COMMENTS:

*SITE VISIT ON 8/27/08 BY OT, JM, BM. PLUMBING STUBBED OUT AT

LOCATION OTHER THAN SPECIFIED ON PERMIT.

## Operation Permit

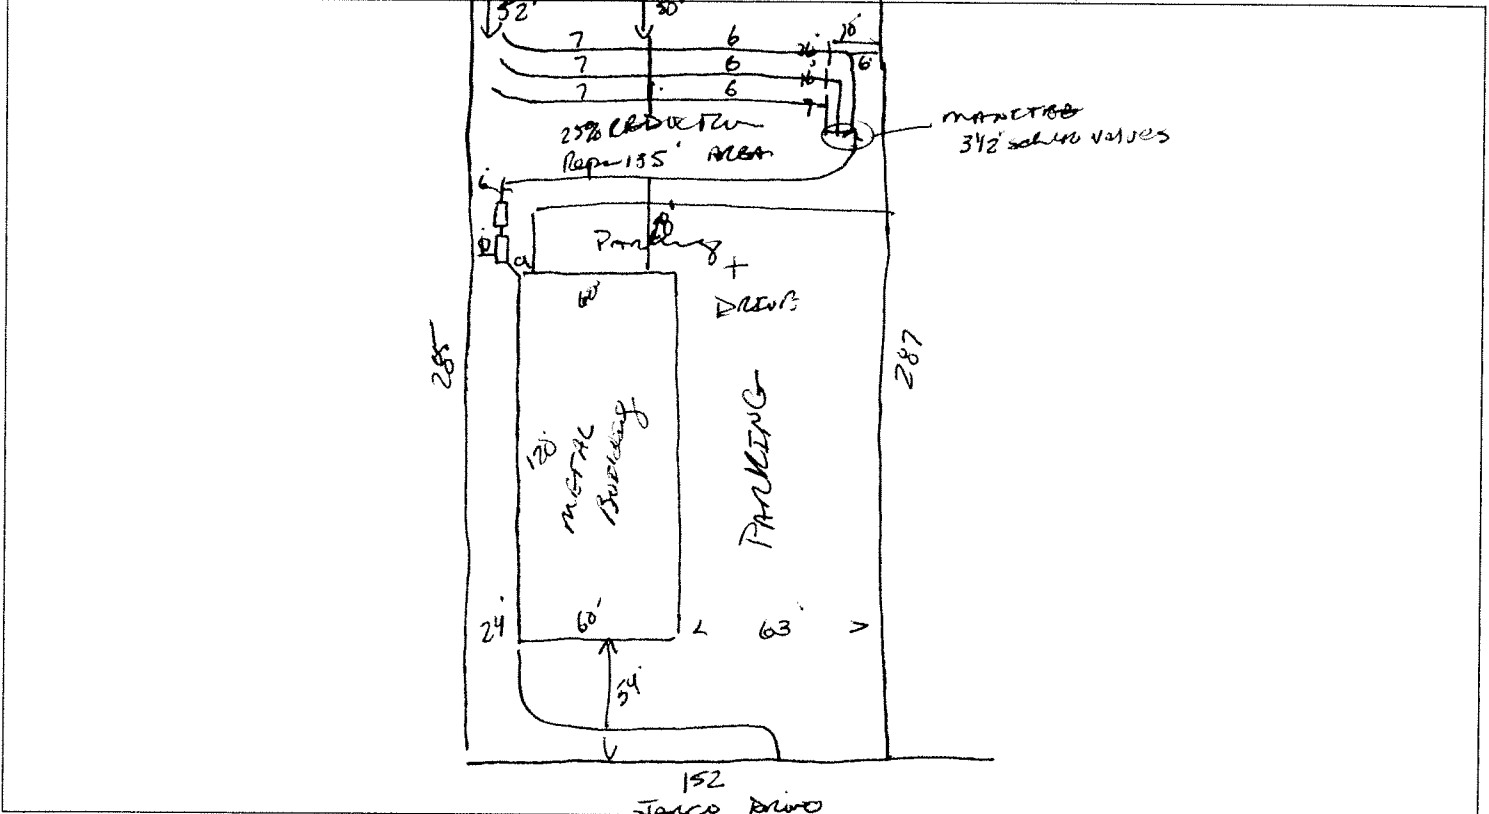
- NEW CA TO BE ISSUED DUE TO NEW TANK LOCATION REQUIRED

- NEW TANK LOCATION MAY REQUIRE TRAFFIC RATED TANK

- SUPPLY ^{LING} MAY NEED TO BE S ^{AS REQUIRED} LEEVED DUE TO DEPTH

- DRAINFIELD ^{+ REPAIR} TO BE FENCED OFF DUE PROXIMITY TO DRIVE

- IF PROPER FALL FROM TANK TO DRAINFIELD CANNOT BE MAINTAINED

A PUMP WILL BE REQUIRED
